Recommendation Report for Planning Permission for Works or Extension to a Dwelling

REF NO: M/70/17/HH

LOCATION: 10 Norfolk Way
Elmer

PROPOSAL: Two storey side extension & loft conversion.

ELEVATION FACING WEST

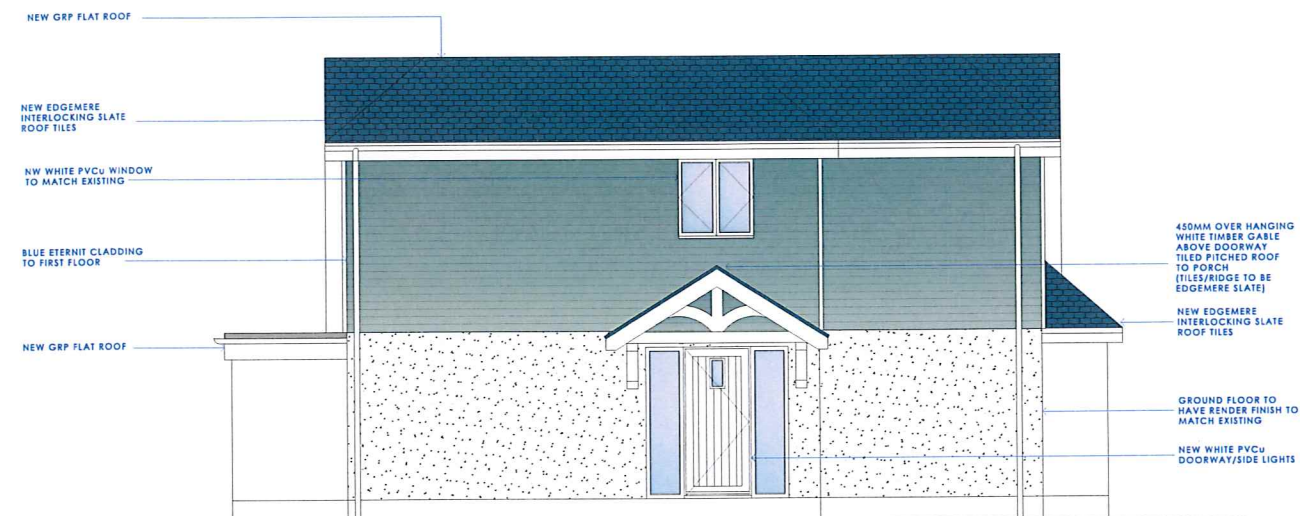
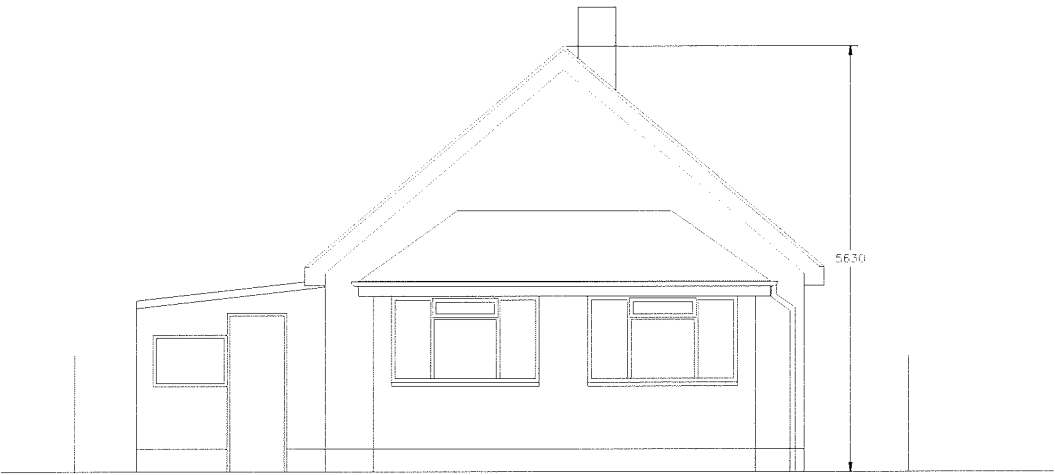
The first floor window of the West of the property is a cause of potential overlooking and therefore will be conditioned to be obscure glazed and fixed shut below 1.7m. The proposal include three windows on the Southern elevation of the property, however the separation distance to the nearest property is over 20 metres which is deemed to be sufficient to prevent any unacceptable loss of privacy.

- 4 The window at first floor level in the Western elevation of the building (as seen on plan - Proposed Plan - PA-247-06) shall at all times be and remain obscurely glazed up to 1.7m with obscure glass and be fixed shut.
